From: Simon Davis
Sent: 31 August 2018 14:13
To: Planning.Responses
Subject: FW: RE: Planning Consultation on: AL/86/18/PL

From: Laura Gibbons
Sent: 31 August 2018 13:21
To: Simon Davis
Subject: RE: RE: Planning Consultation on: AL/86/18/PL

B	show unit 3 plus drainage details.	8/18
A	Add drainage and delete storage of 2 caravans	5/13
Mr. J. Horton		
The Old Barn, Arundel Road, Fontwell. BN18 0SX		Richard Stubbs MRTPI
		TEL: 01243 825944
Mobile Home (3rd Unit)		06/12/B
1:2500	1:500	August 2018
		1 of 1

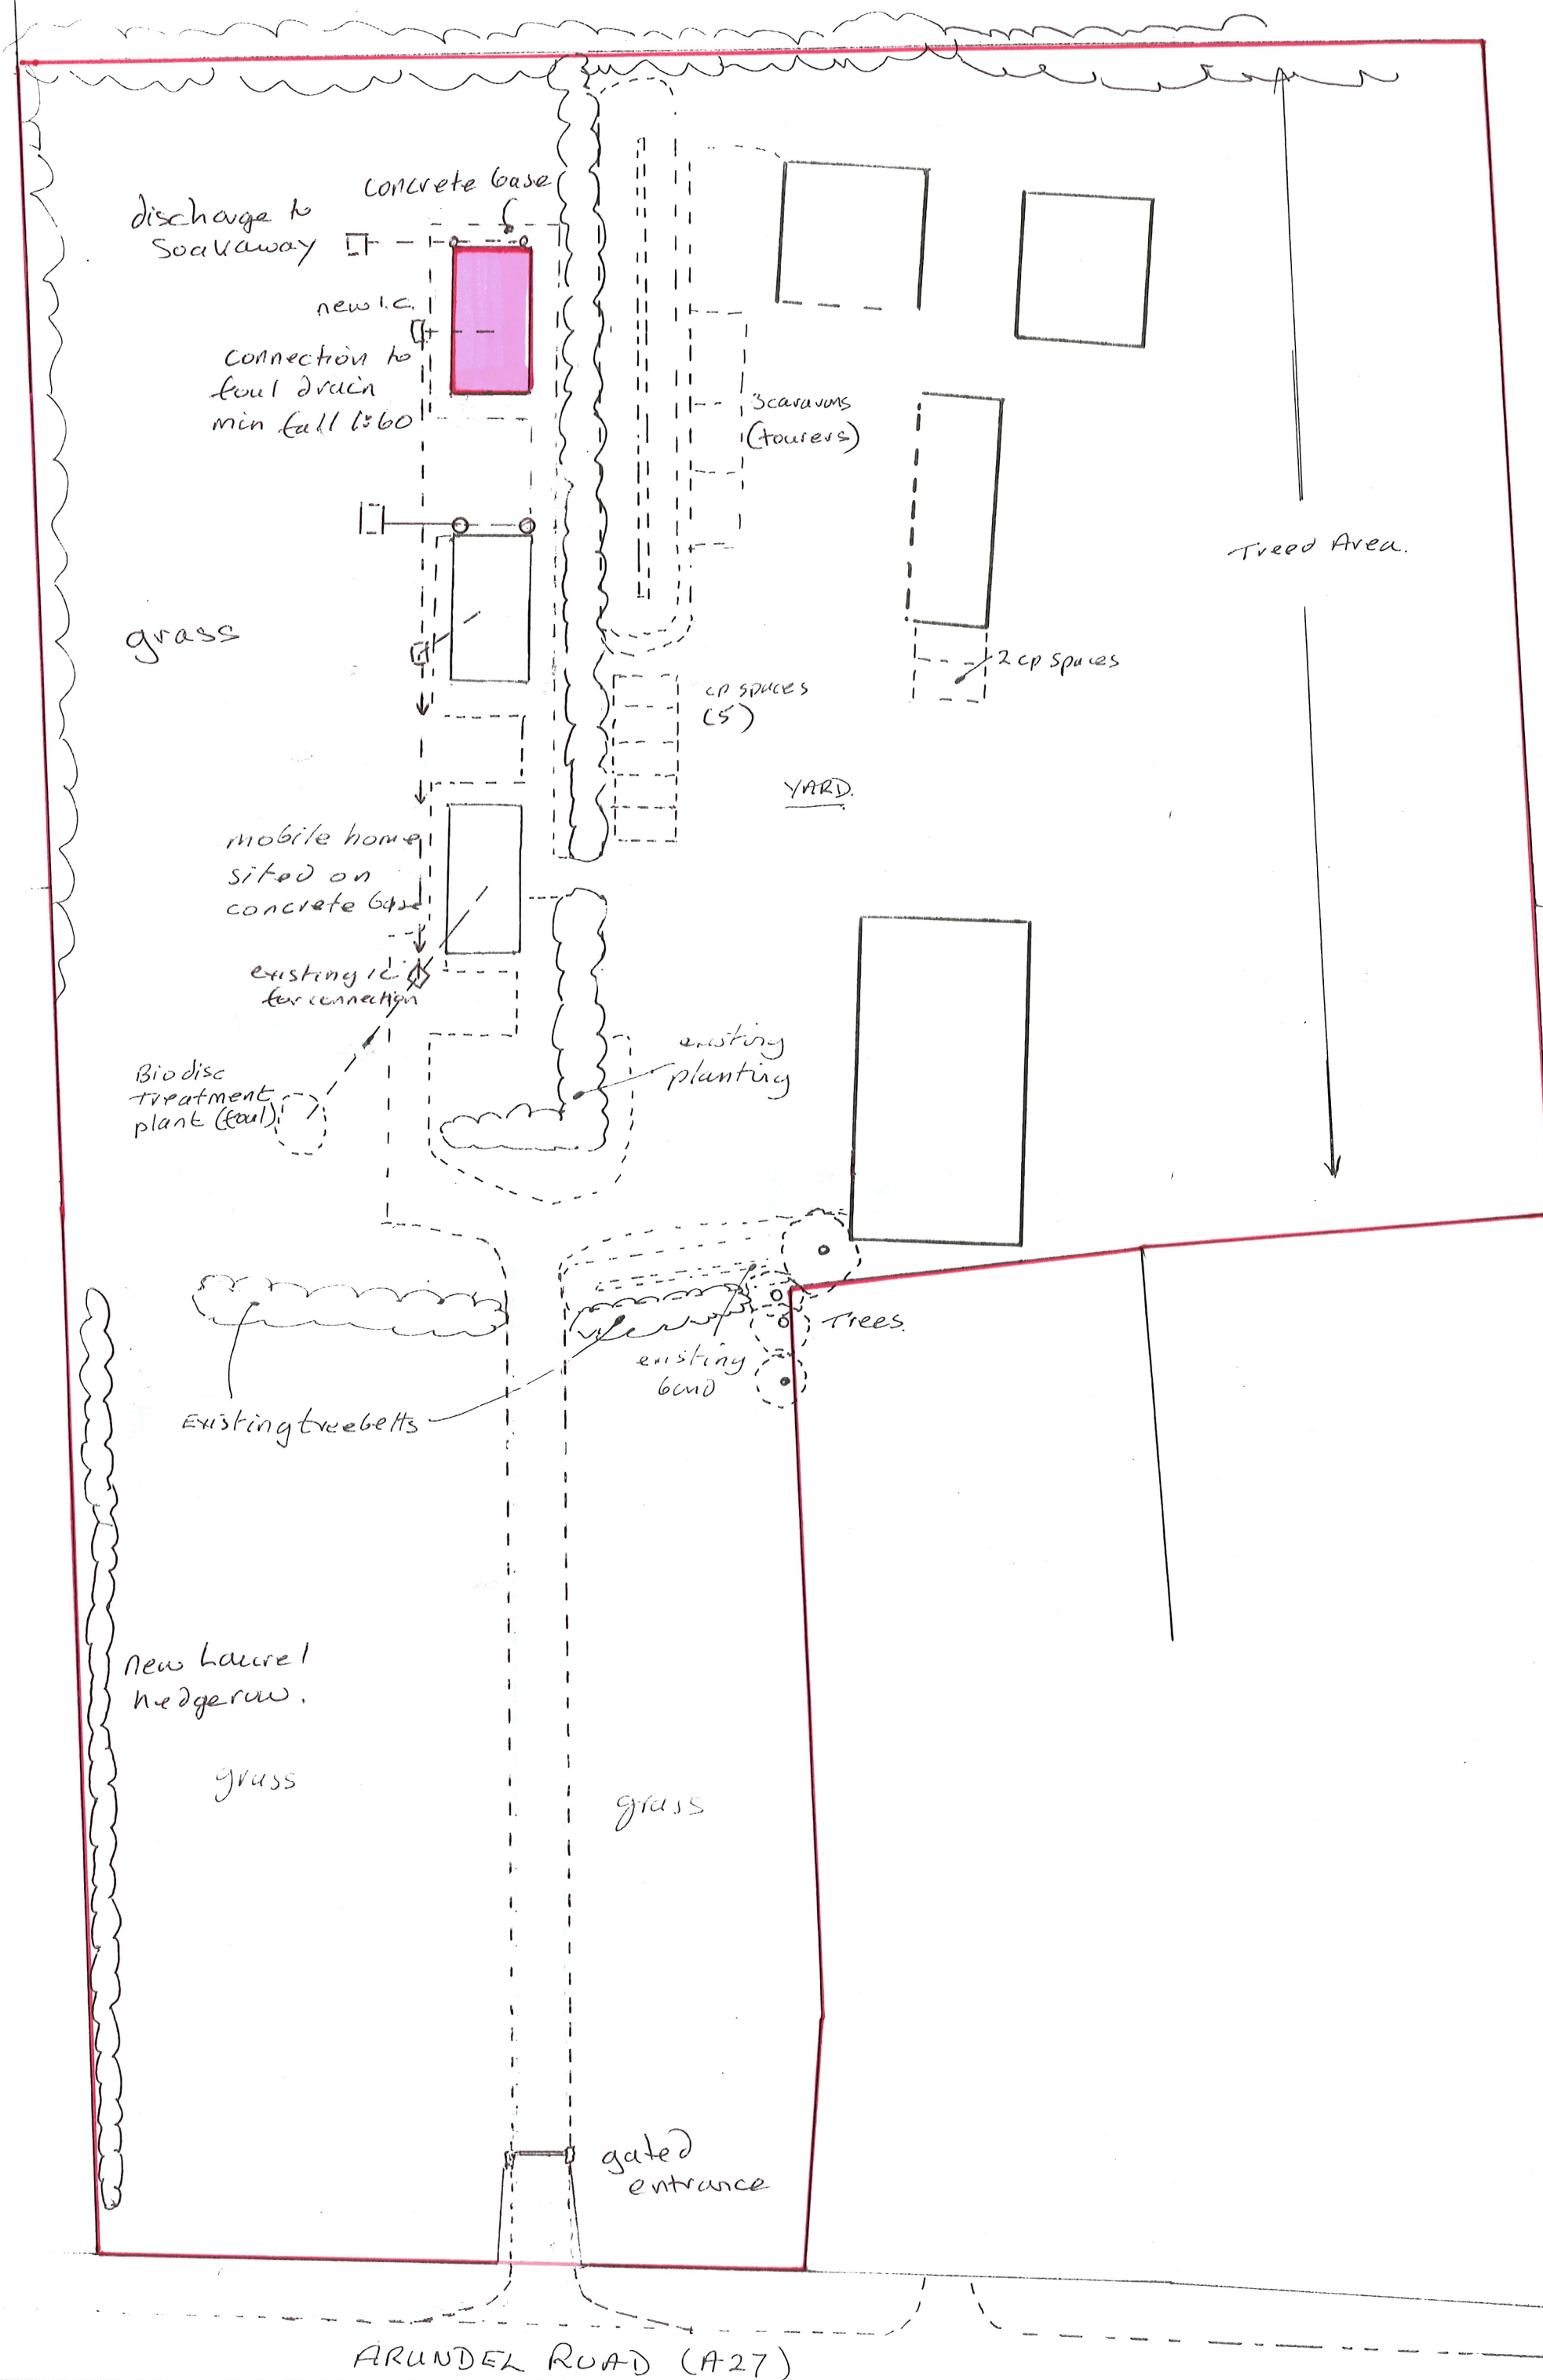
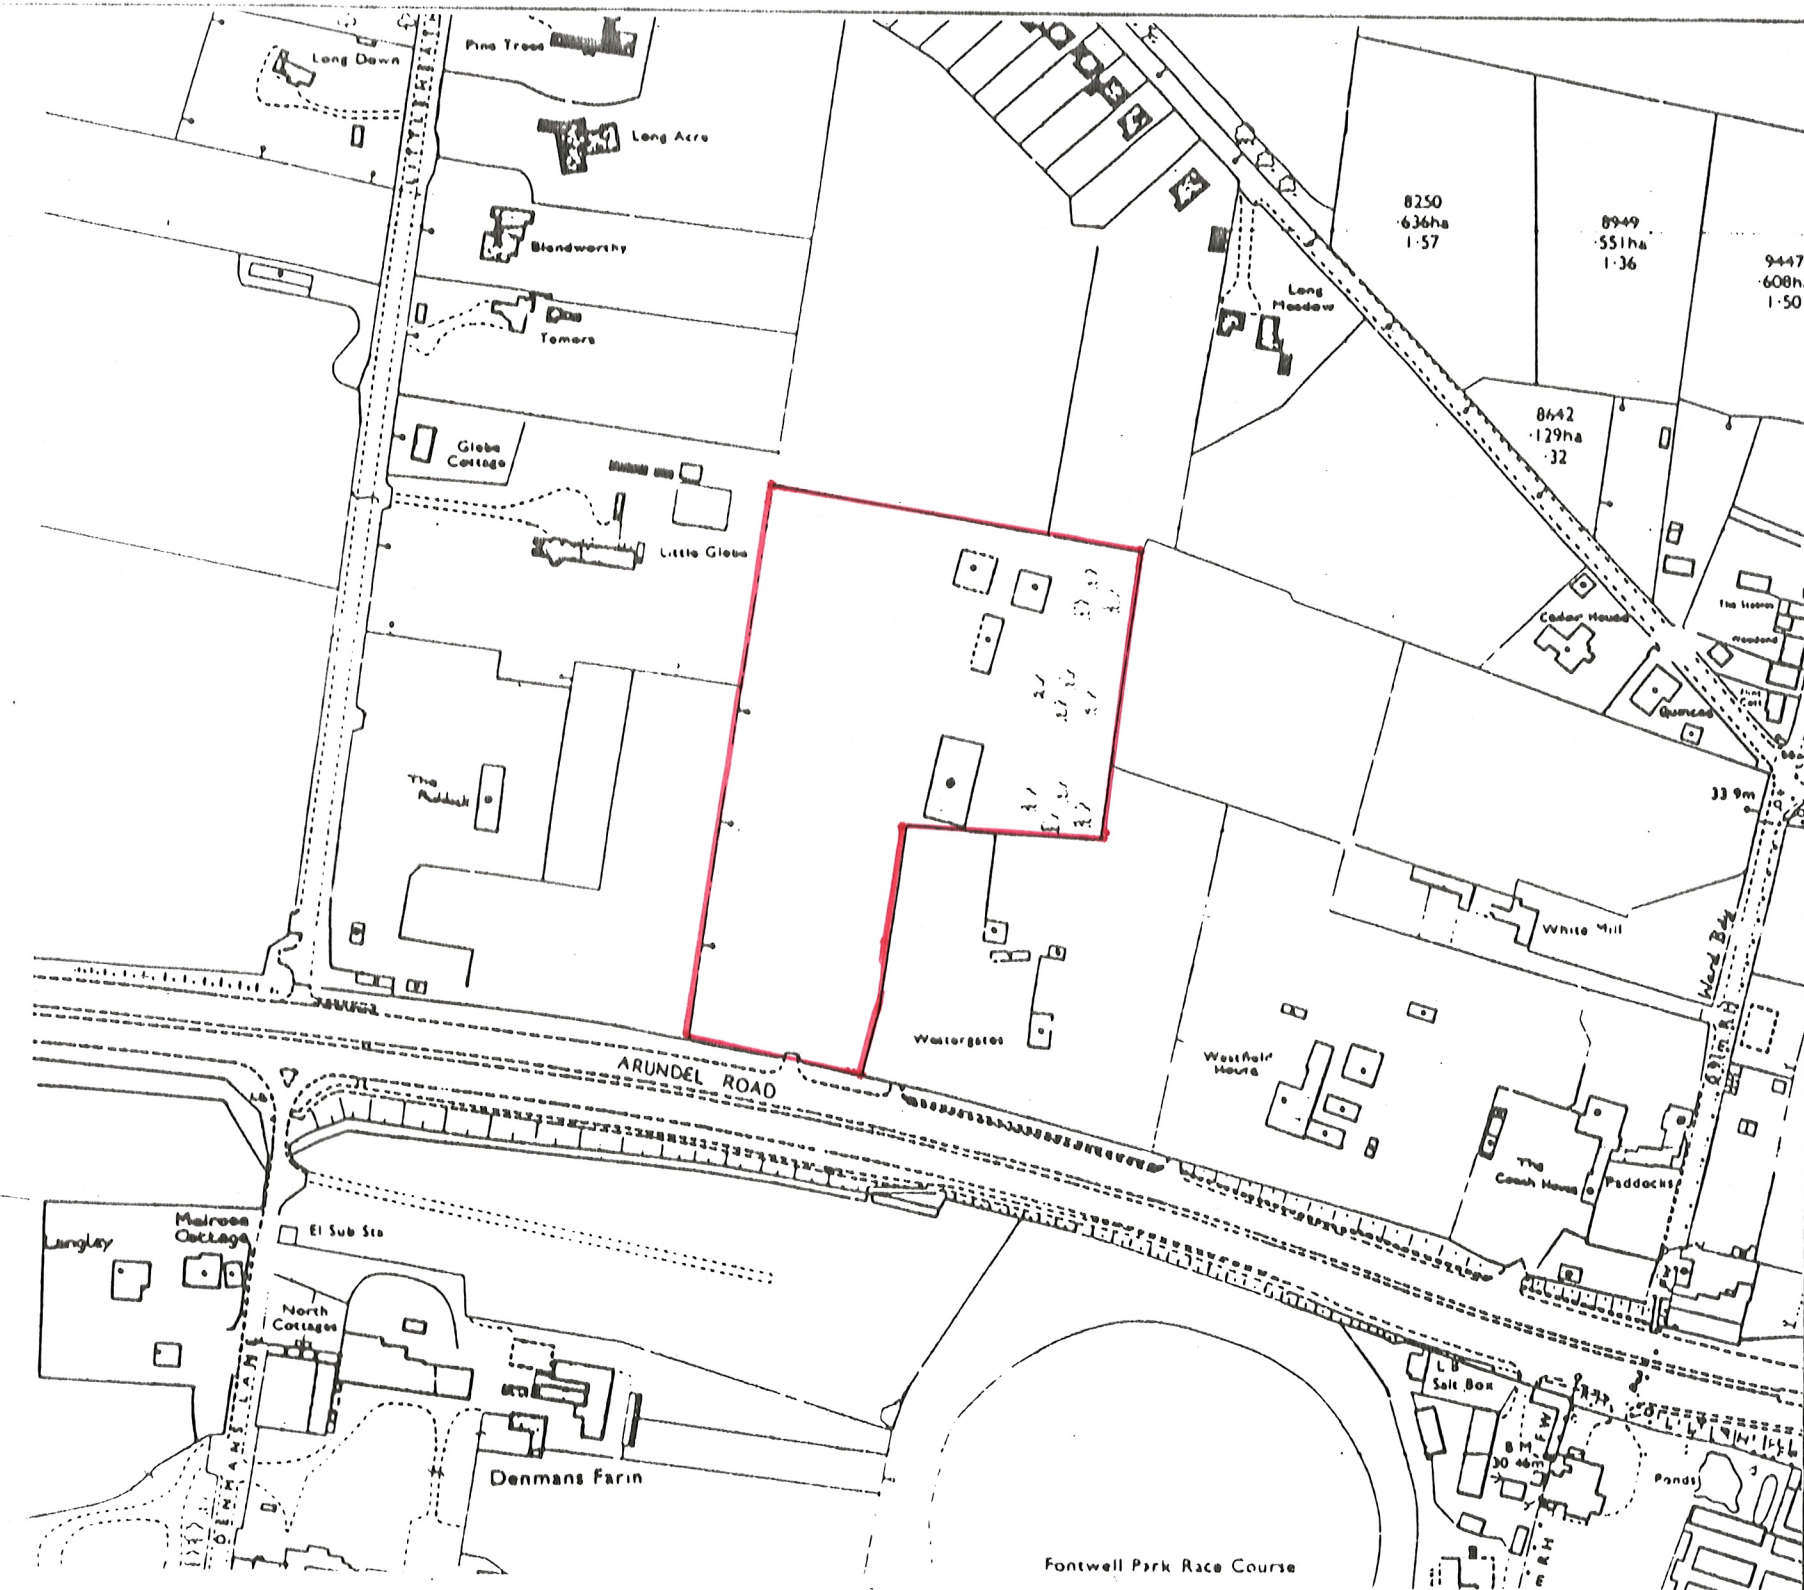
It will need to be demonstrated that the SuDS scheme provides sufficient reduction in pollution concentrations before the water is allowed to infiltrate. This can be achieved via ensuring water is held for a set duration before it is allowed to infiltrate, by passing water through various medium such as permeable paving, etc.

"It should also be noted that the site is within a groundwater source protection zone, therefore sufficient treatment of water to the ground will have to be demonstrated."
